Council Advice on the Environmental Impact Statement for 'STACK SYD01 Data Centre - SSD-82211208 - 78 Lockwood Road Data Centre, Erskine Park, NSW, 2759

Thank you for providing Penrith City Council the opportunity to comment on the subject Environmental Impact Statement (EIS).

Council has reviewed the information referred for comment on 03 December 2025 and provides the following advice for the Department's consideration.

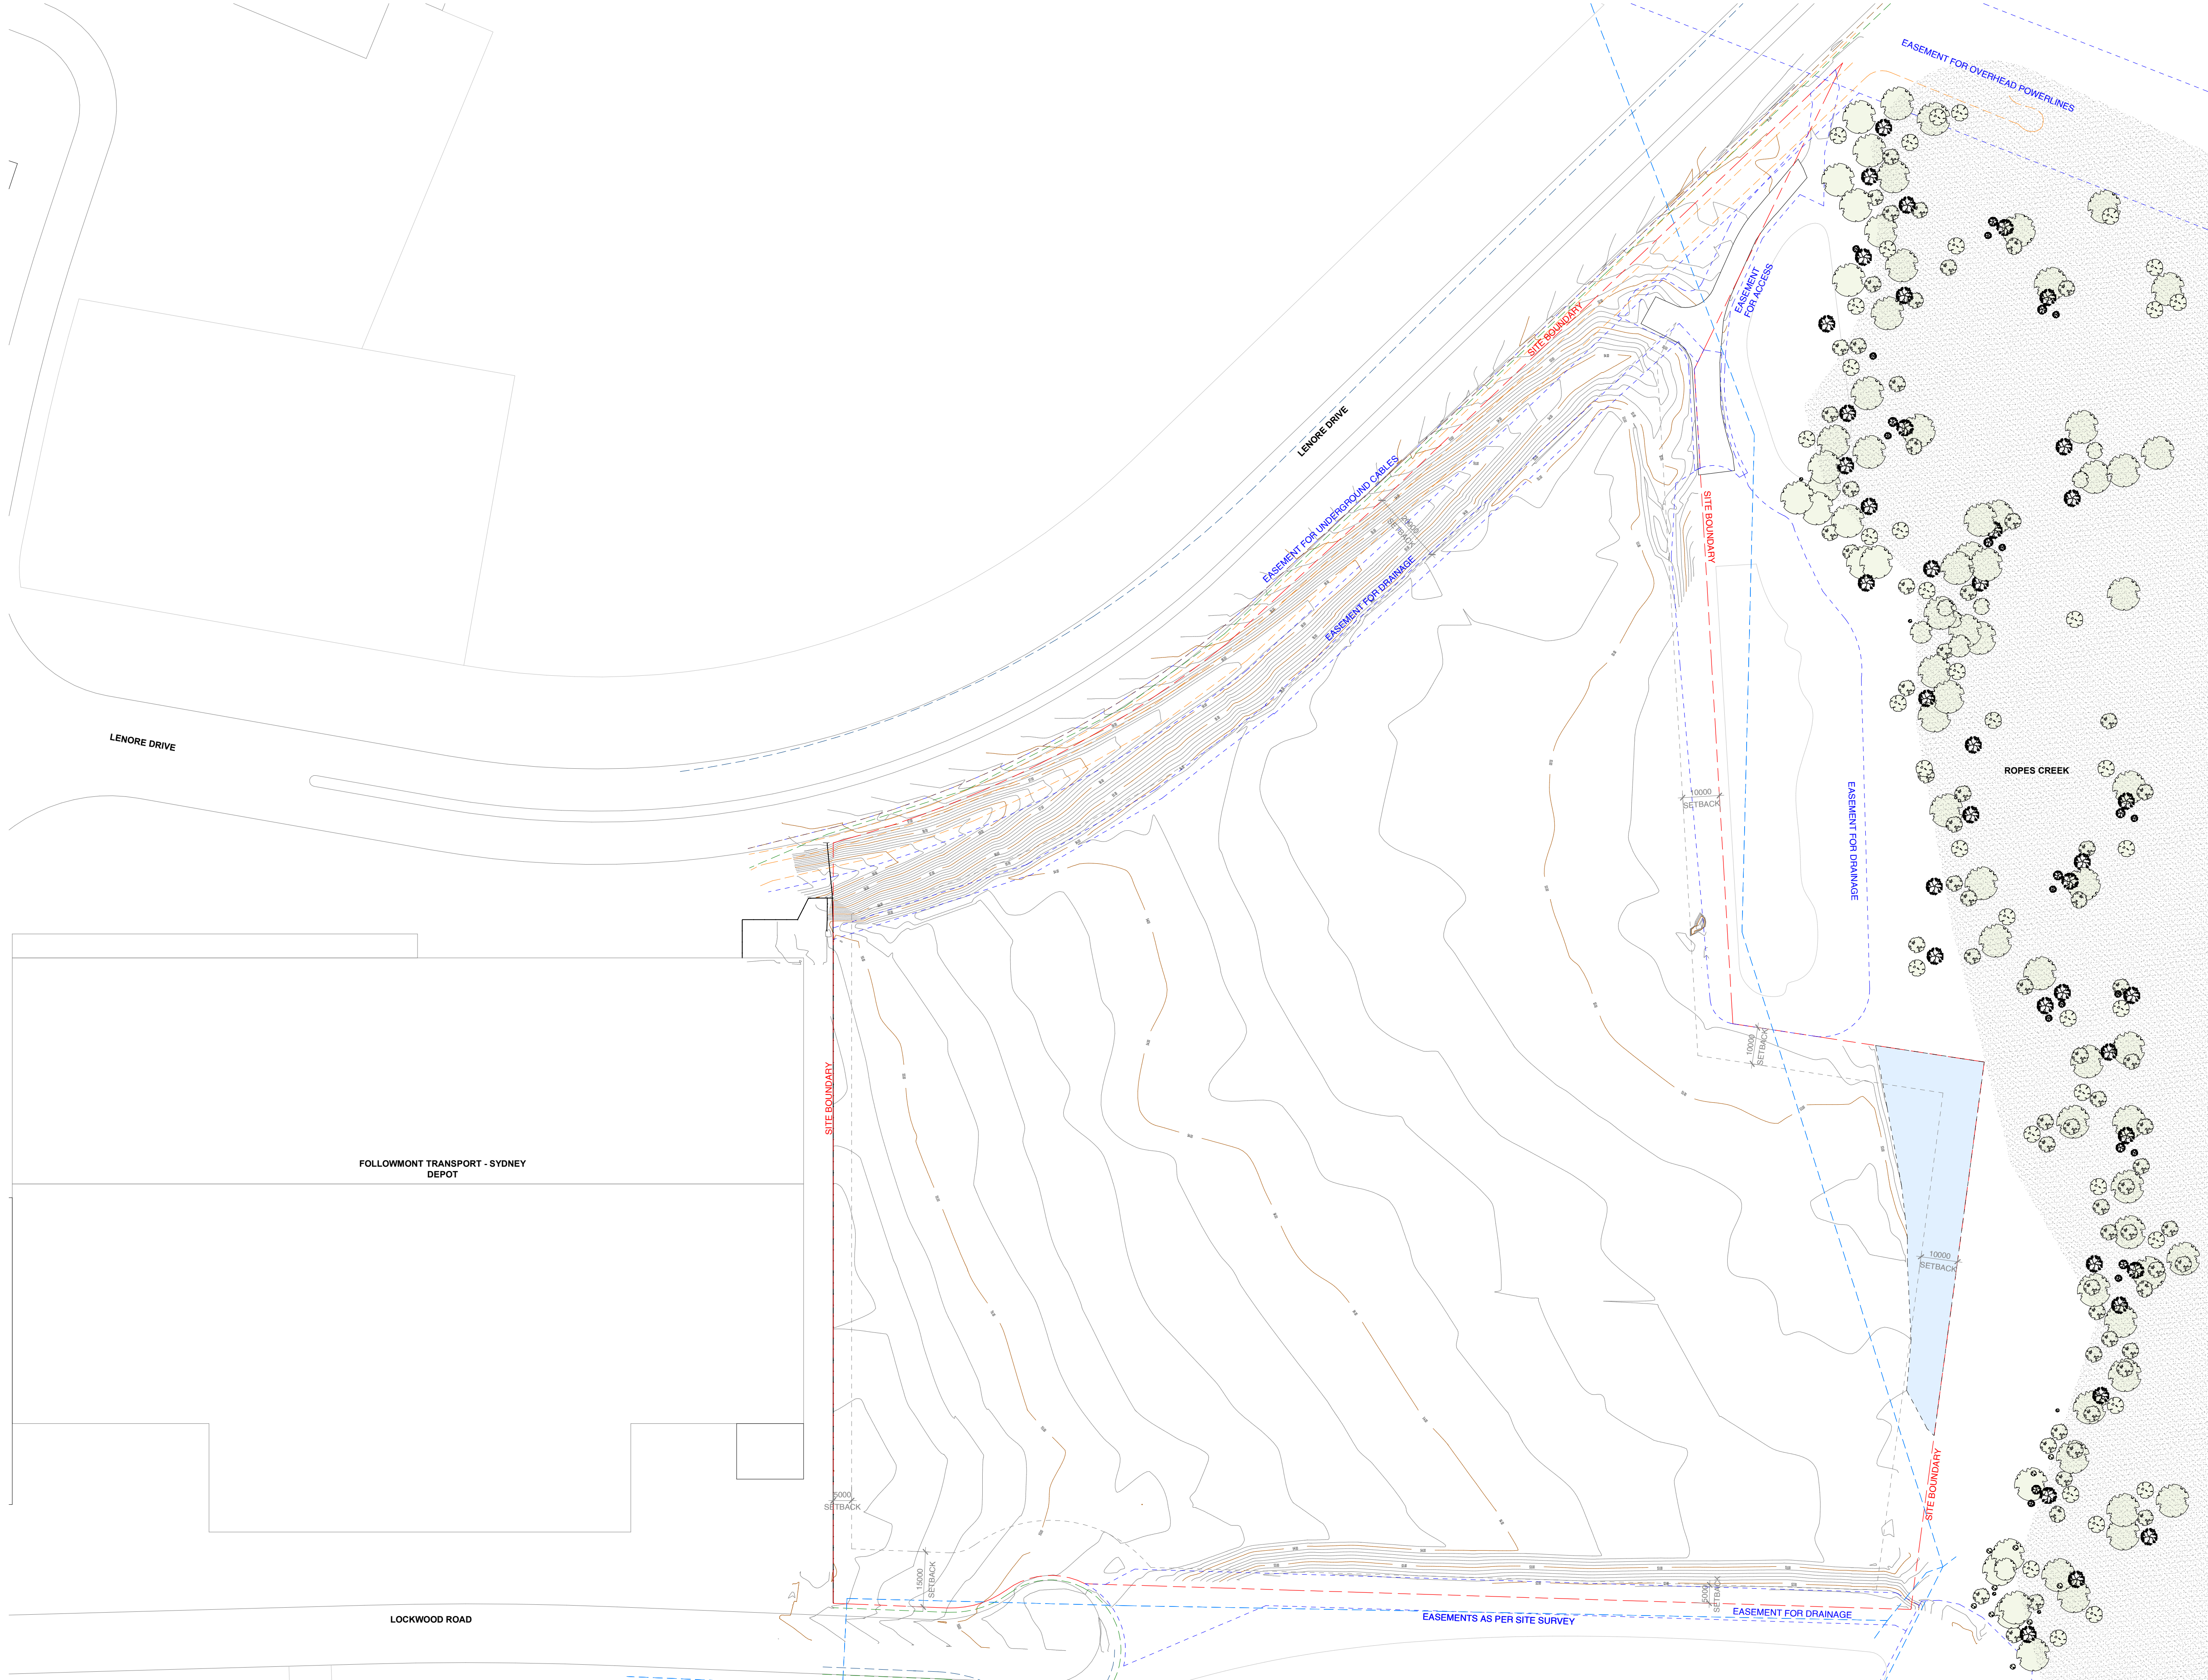
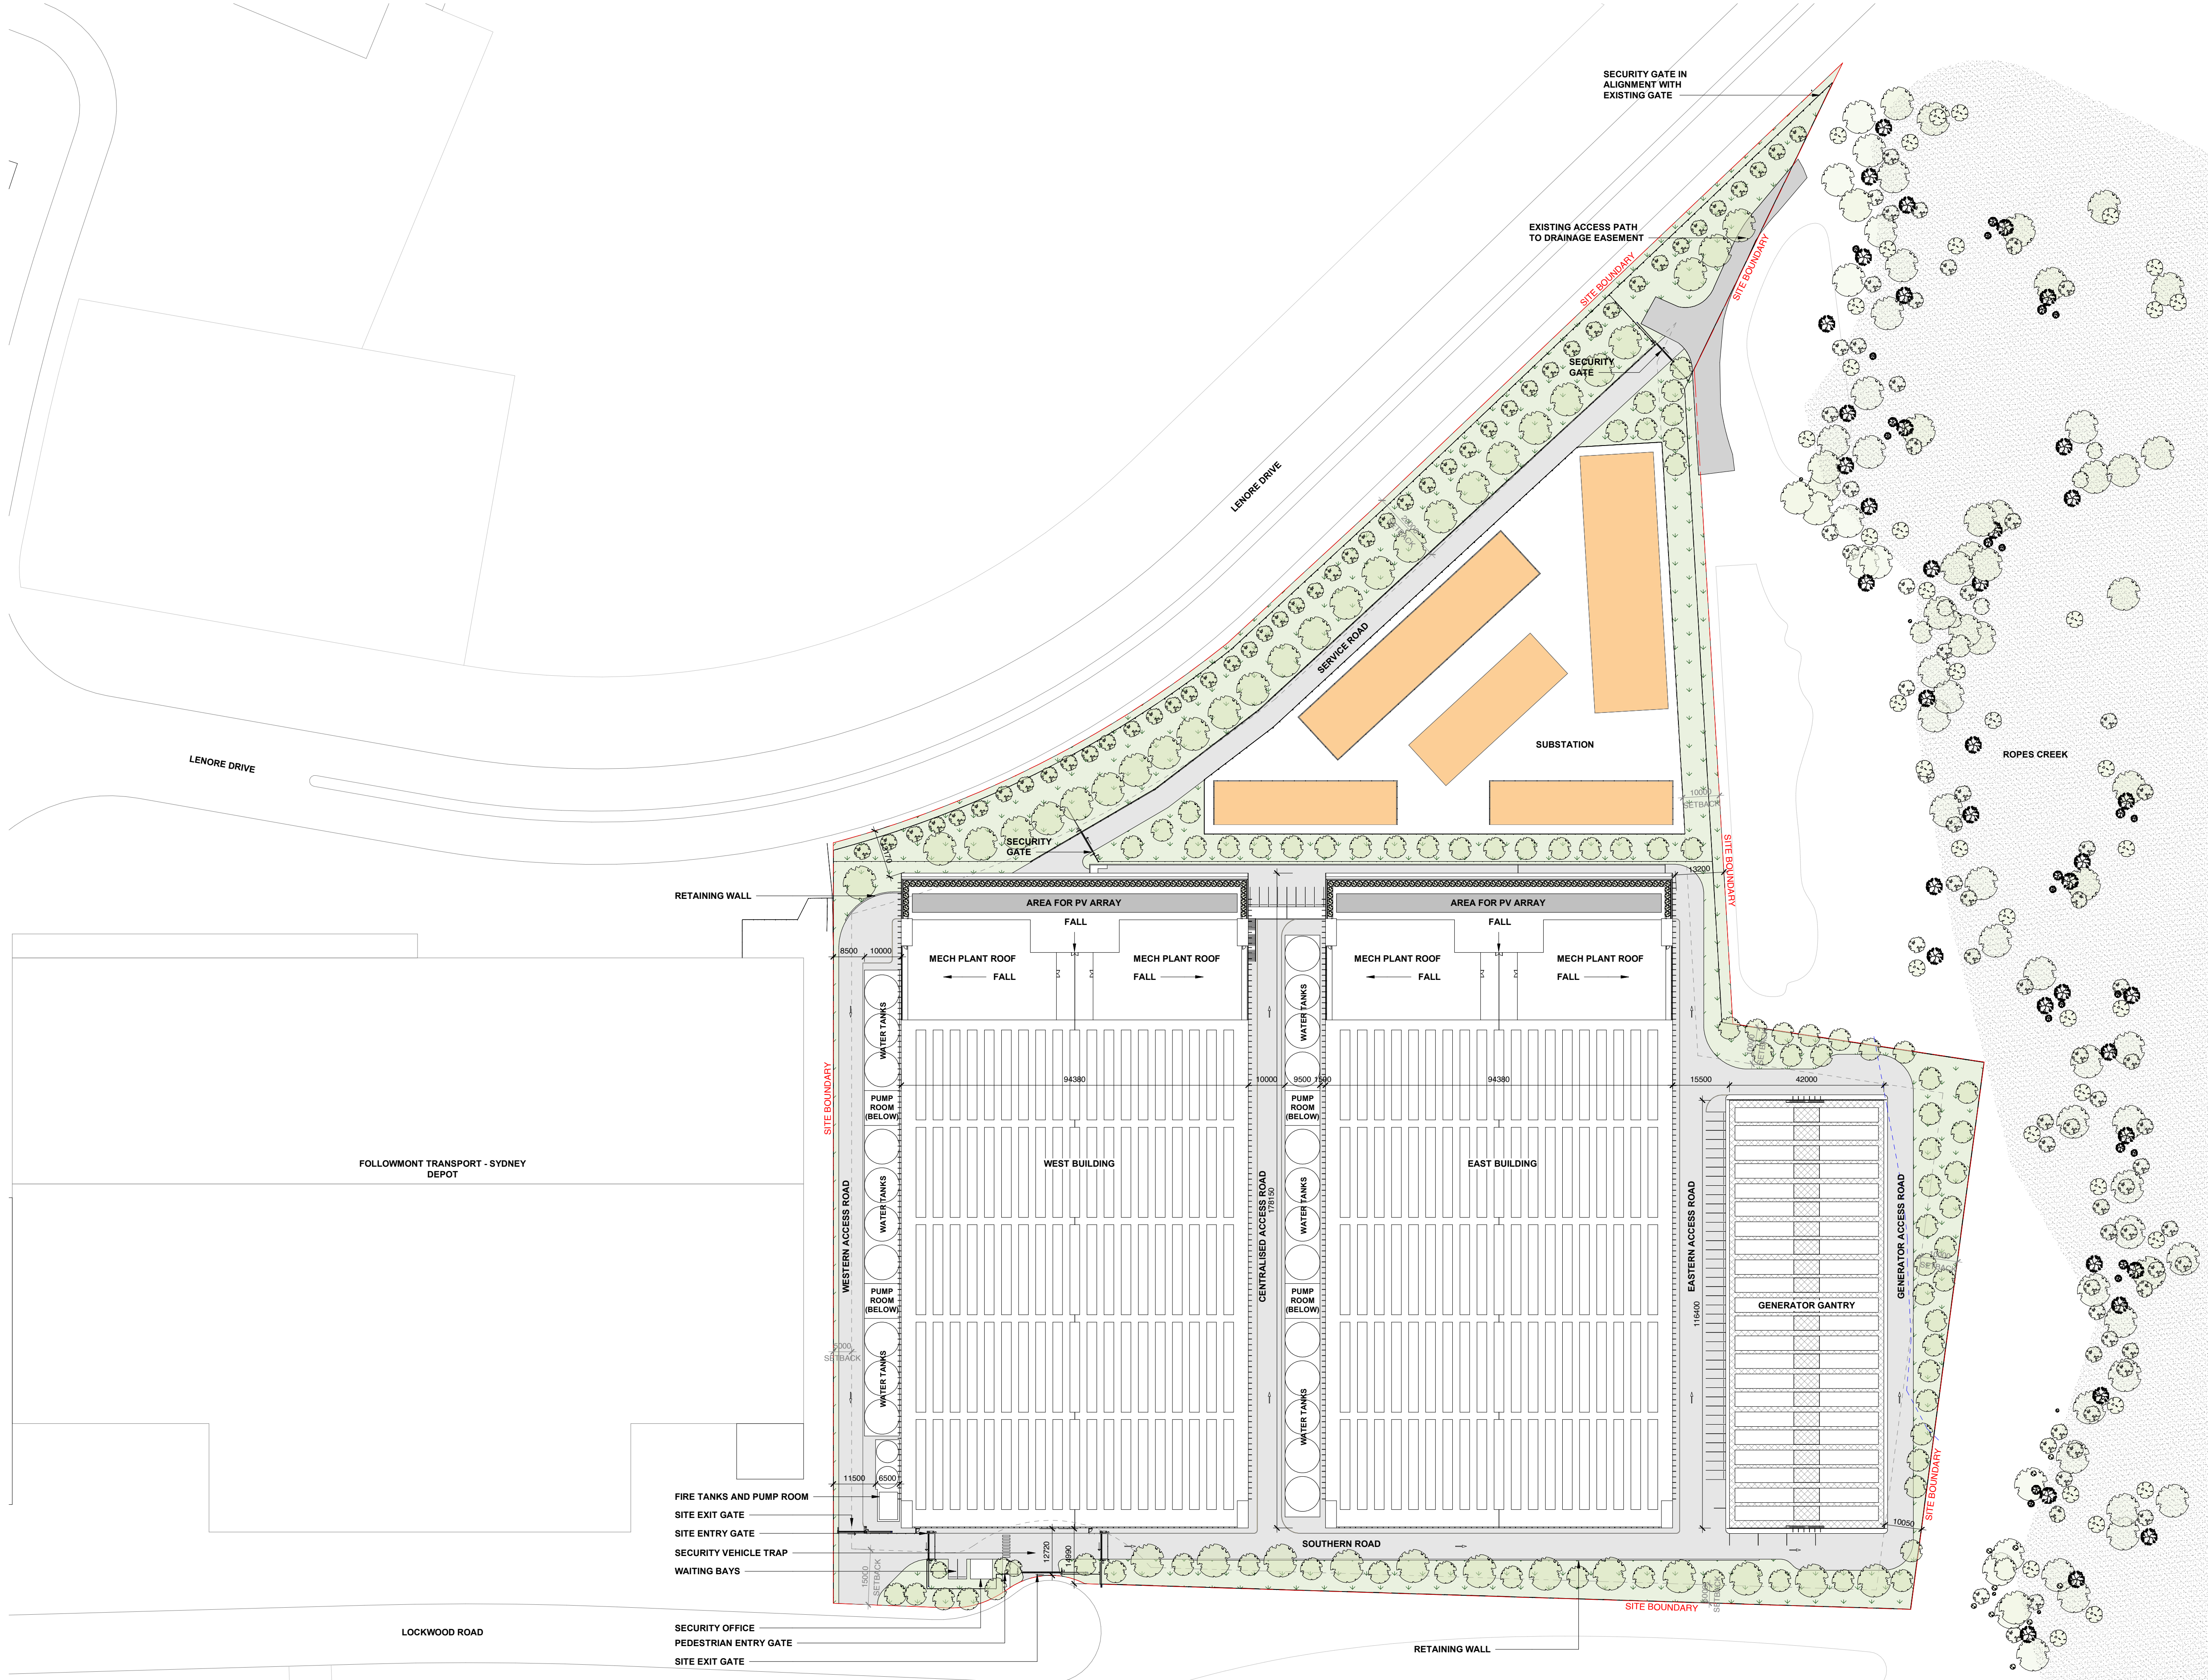
- g) The proposed spatial planning results in some portions of the setbacks from Lenore Drive and Lockwood Road being less than the required 20m and 15m as per Chapter E6 of the Penrith DCP. This non-compliance, coupled with the non-complying site coverage, proposed building height, and large building footprint should be considered by DPHI in relation to visual impact and landscaping.

- a) The site is flood affected by local overland flow flooding from the local catchment. An extract of the local overland flood flows through the western portion of the site is attached. There is an access road proposed around the eastern side of the generator gantry area that is within the 1%AEP flood affected area of the site. There will be associated retaining walls, footing and/or associated batters associated with any works in this area that are not clearly indicated. It is recommended the generator gantry area and associated service roads and the full extent of any battering or retaining structures required be designed clear of the 1% AEP flood extent.

- b) It is recommended the DPHI does not support any works or any filling within any portion of the site affected by the 1% AEP.
- c) An application can be made to Council to obtain Council's current adopted flood extent for the site. A Flood Level Enquiry request is to be made to Council via the Flood Level Information application
